Development Management
Lincolnshire County Council
County Offices
Newland
Lincoln LN1 1YL
Tel: 01522 782070
developmentmanagement@lincolnshire.gov.uk

Application Ref: H16-0692-25

Proposal: **Development of site to provide a food store and drive-thru, along with all associated works and access**

Location: **Land to the south of Holbeach Road, Spalding, Lincolnshire, PE12 6JP**

Appendix E
Traffic Flow Diagrams

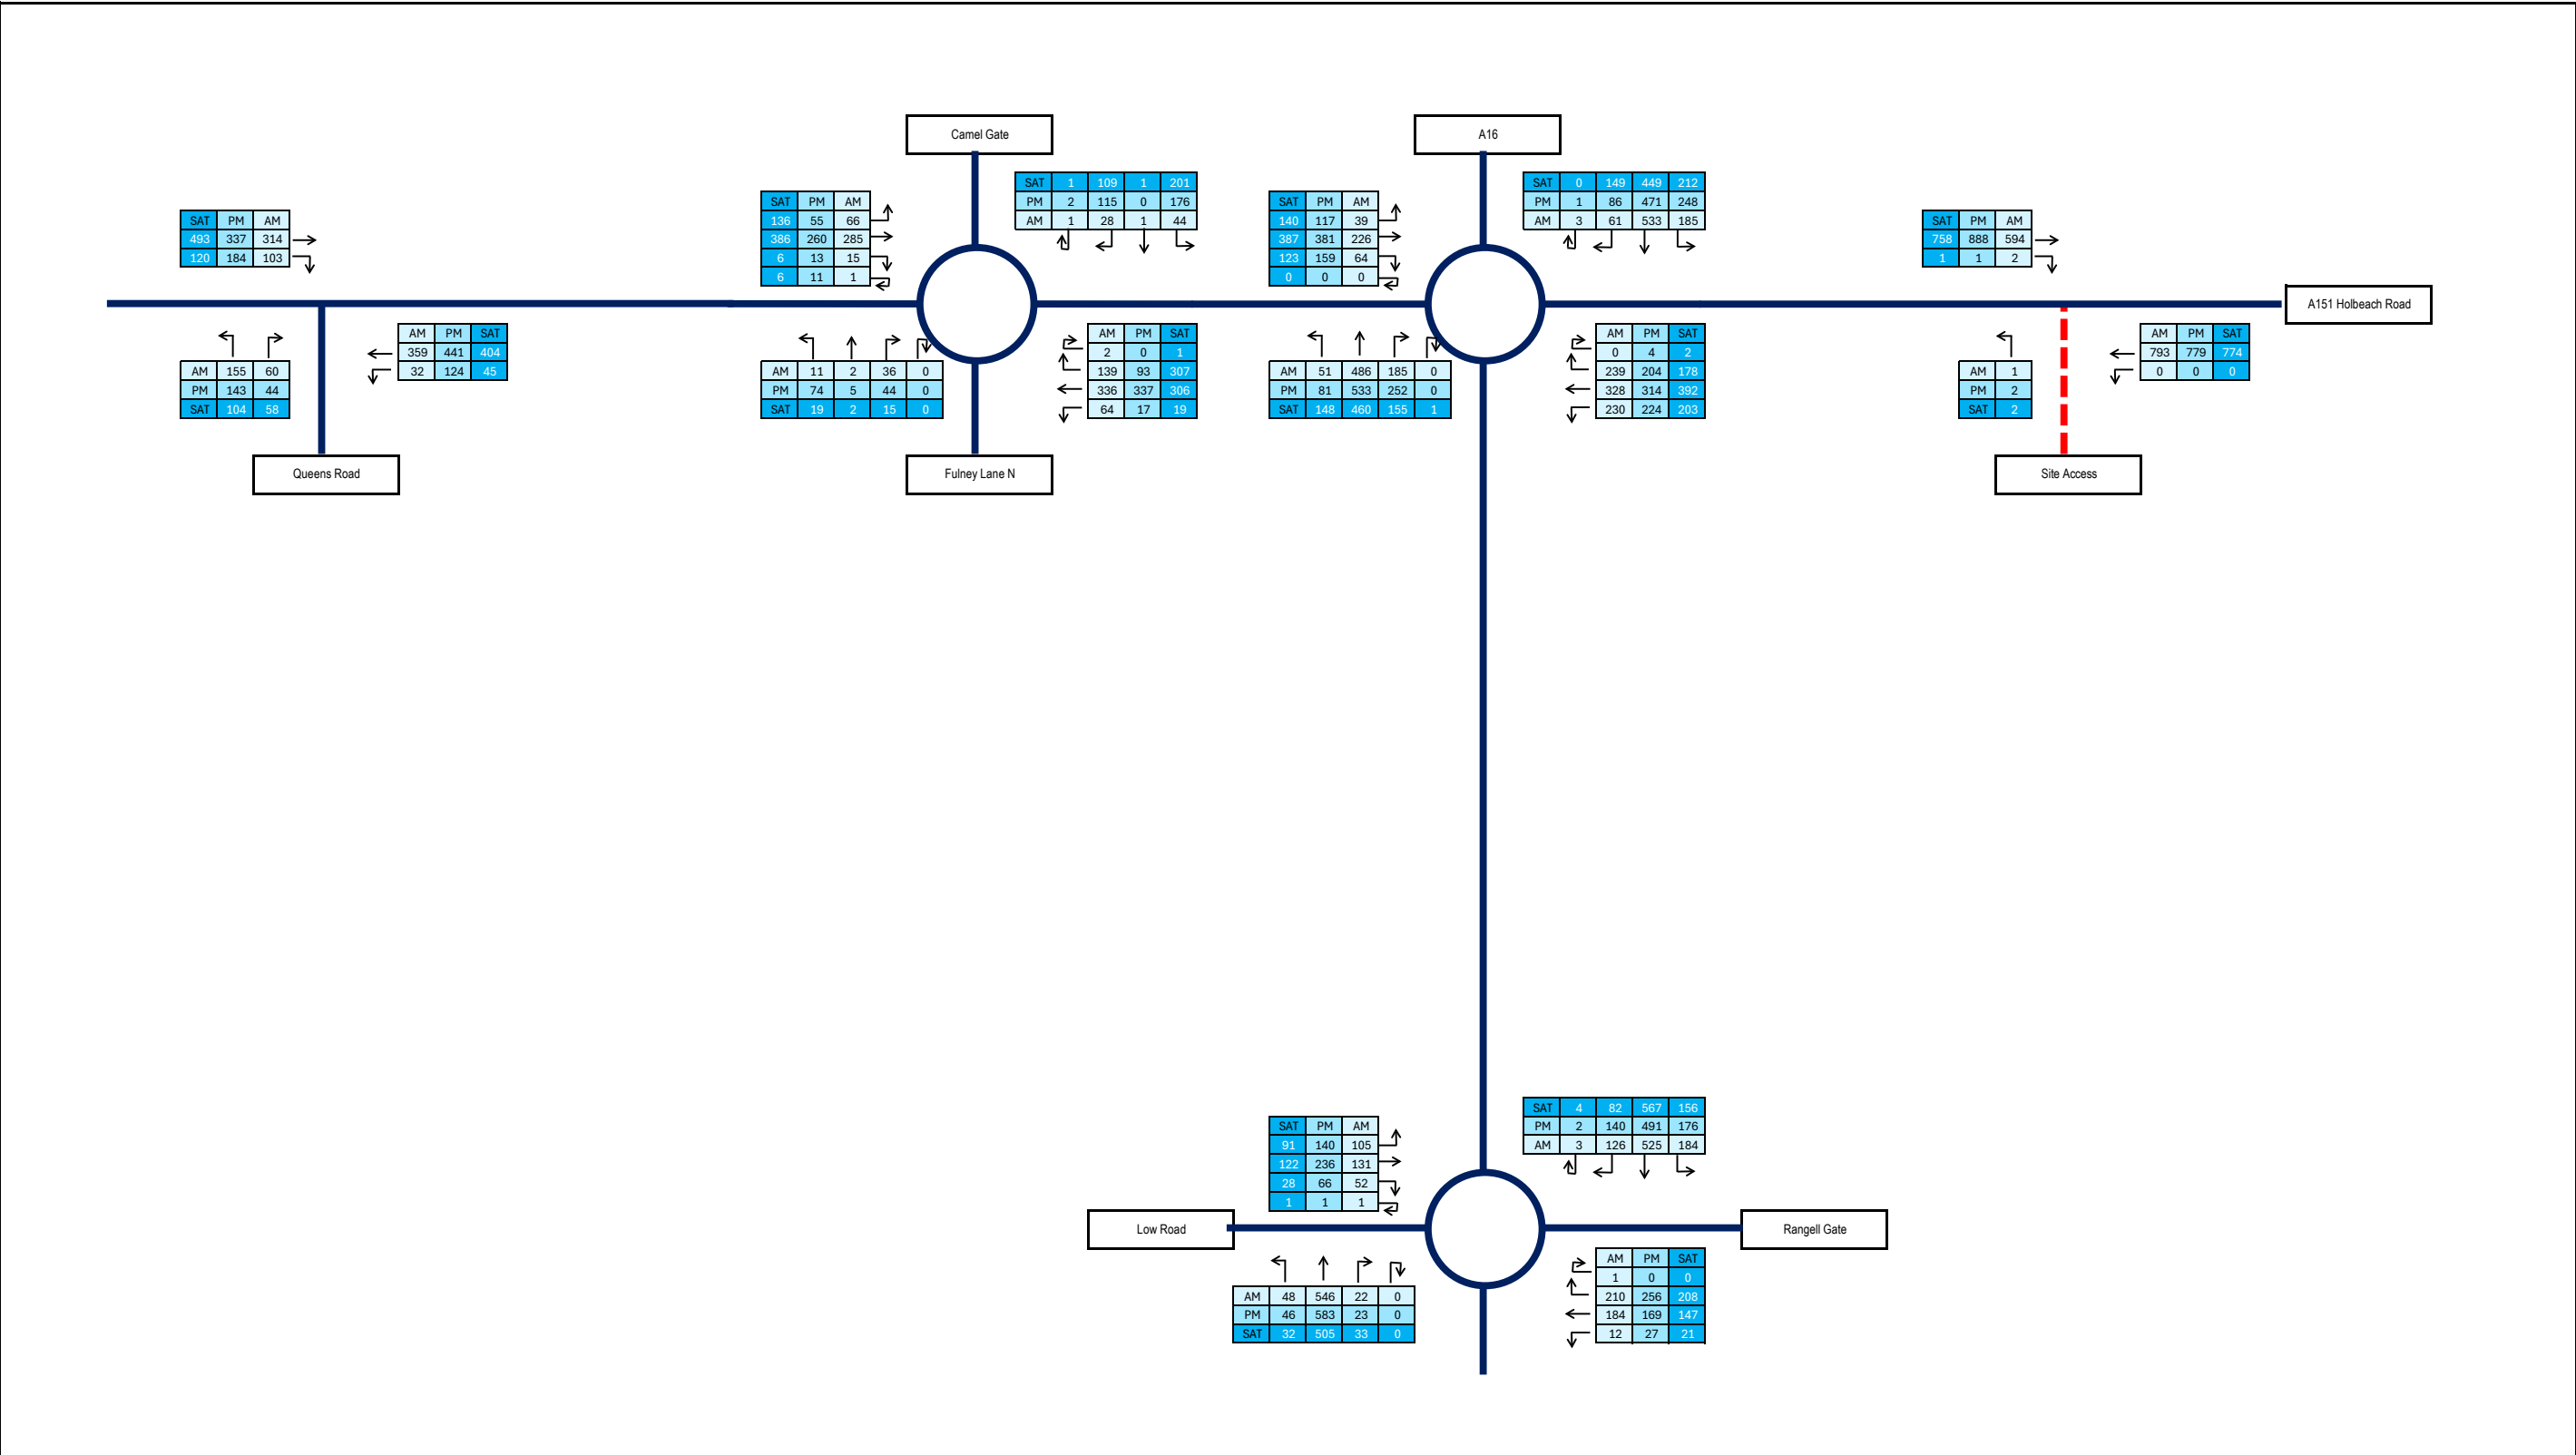
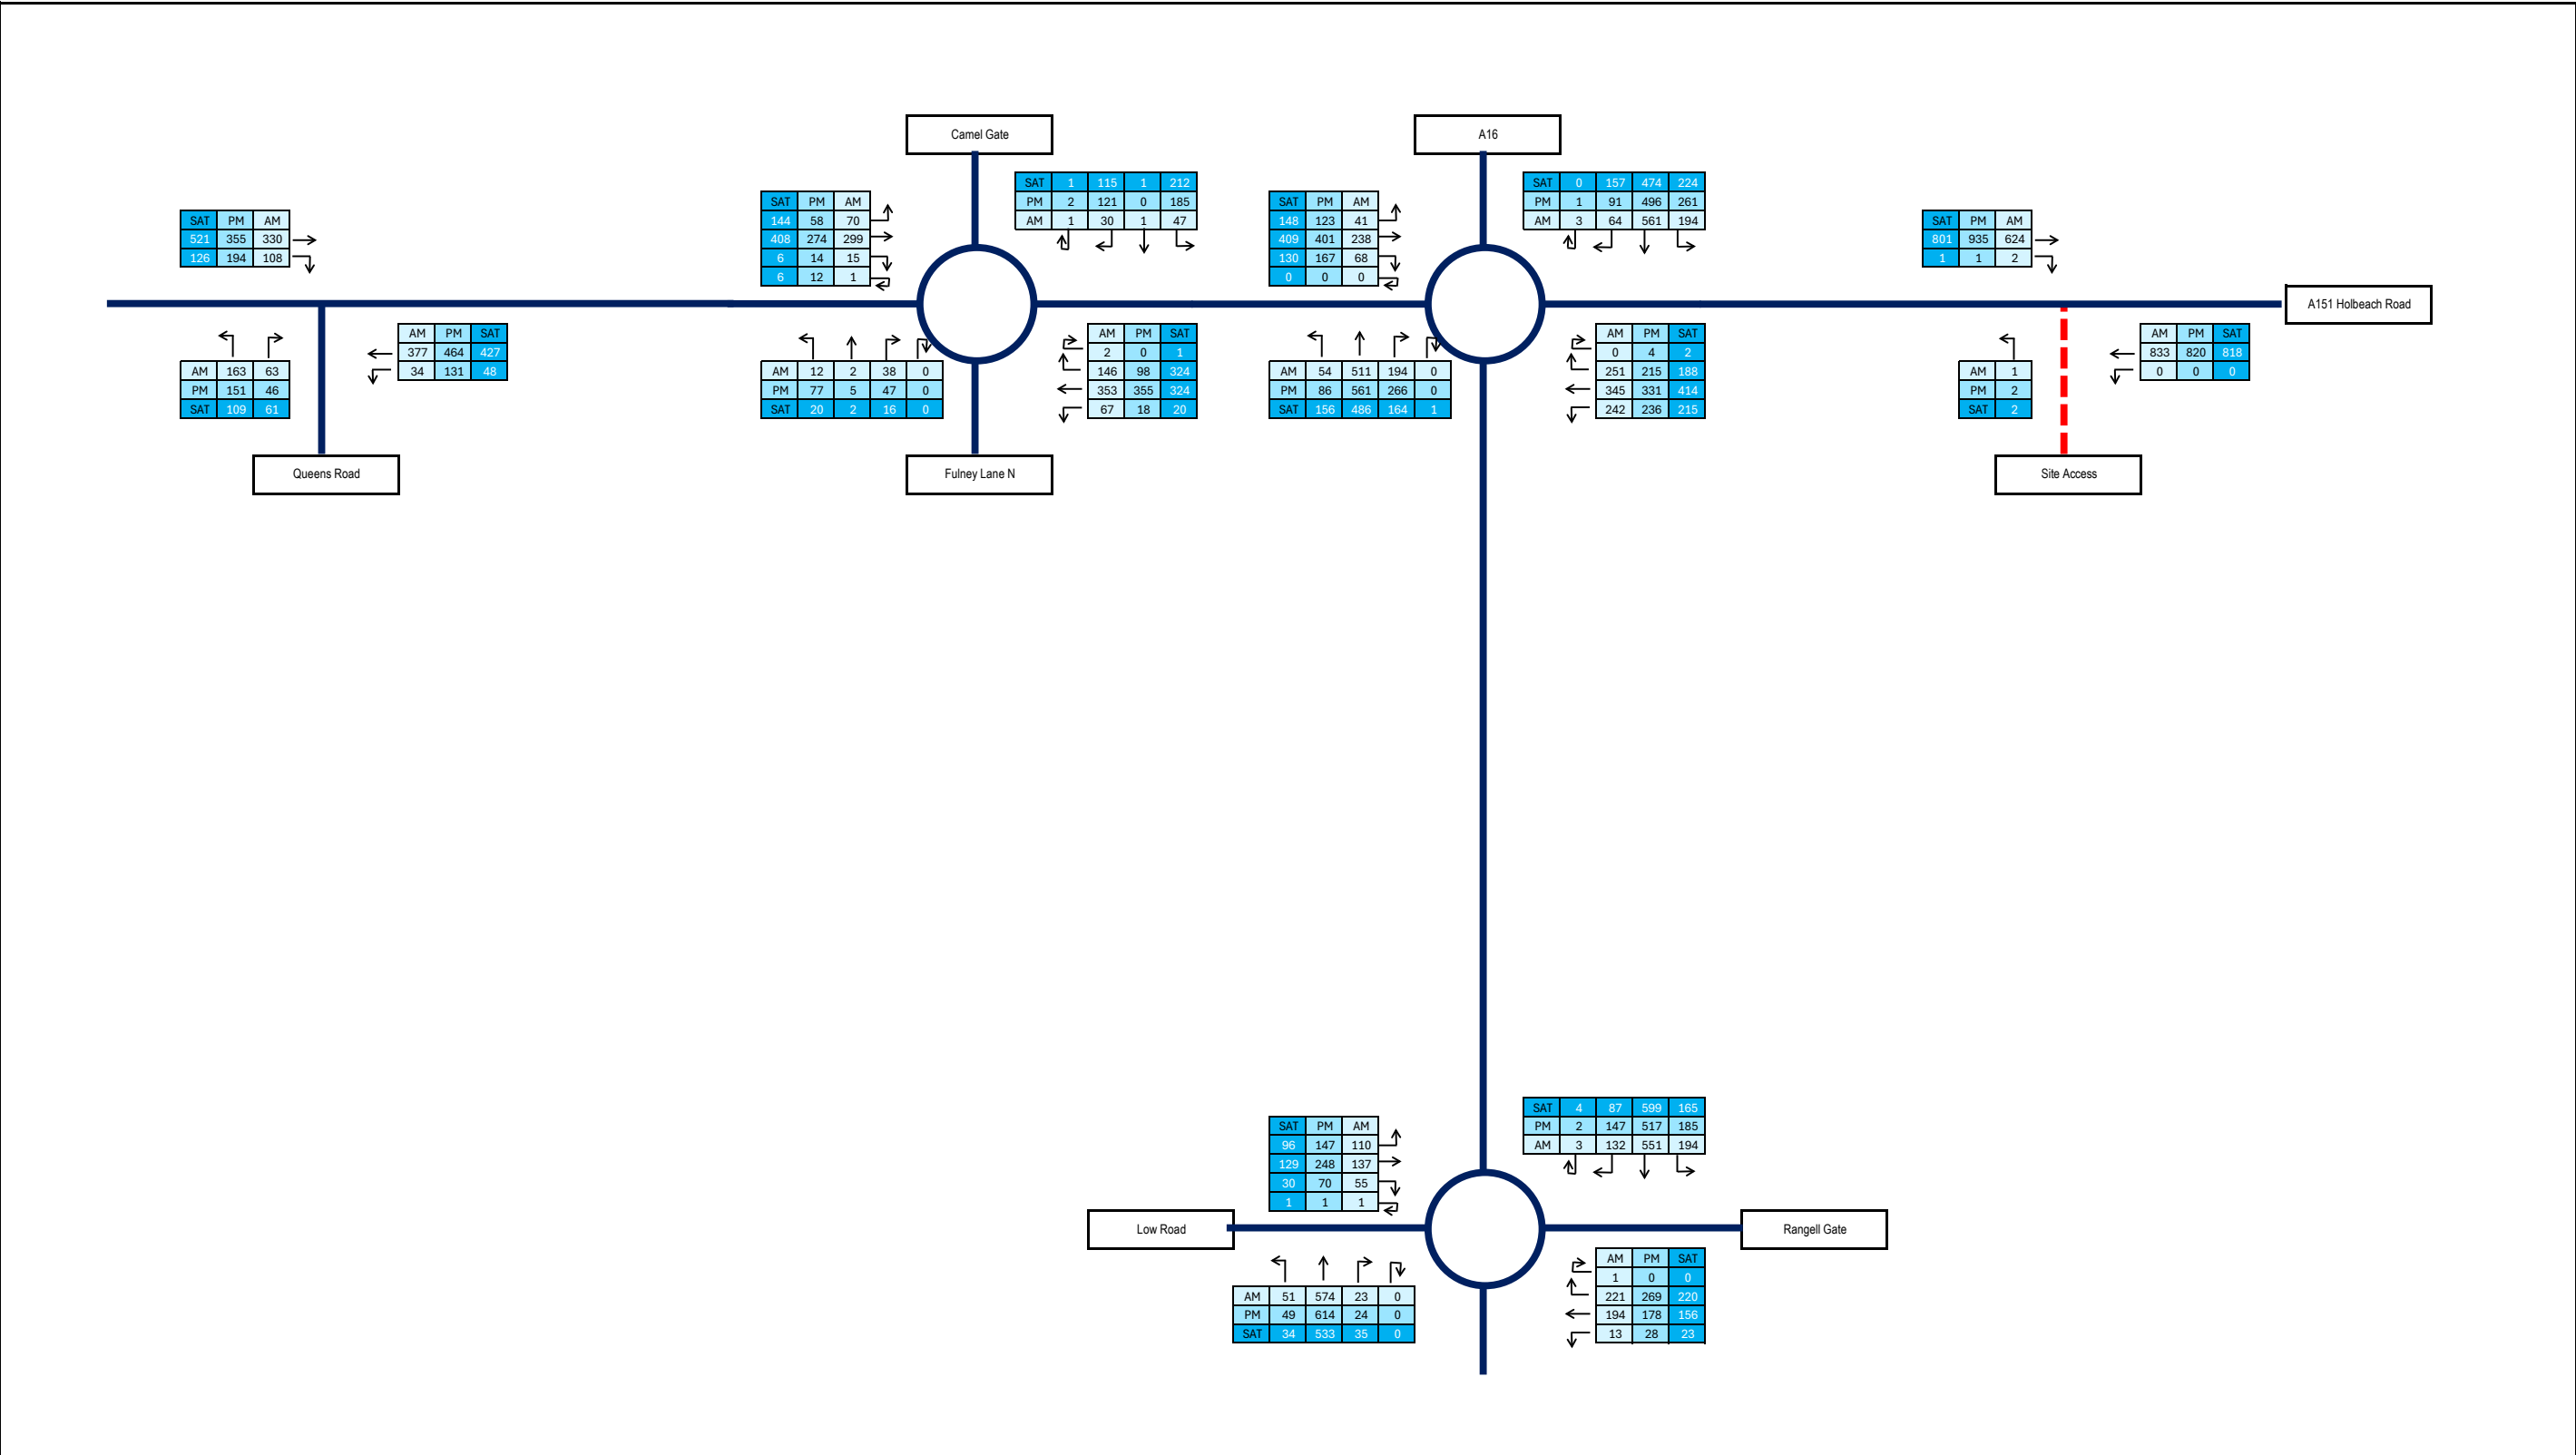
The tracking is unworkable at peak hours as HGV's will need to take up both lanes exiting the site. The swing that is needed can't be achieved on the access road without moving the stone pillars – we need security that they can be moved.
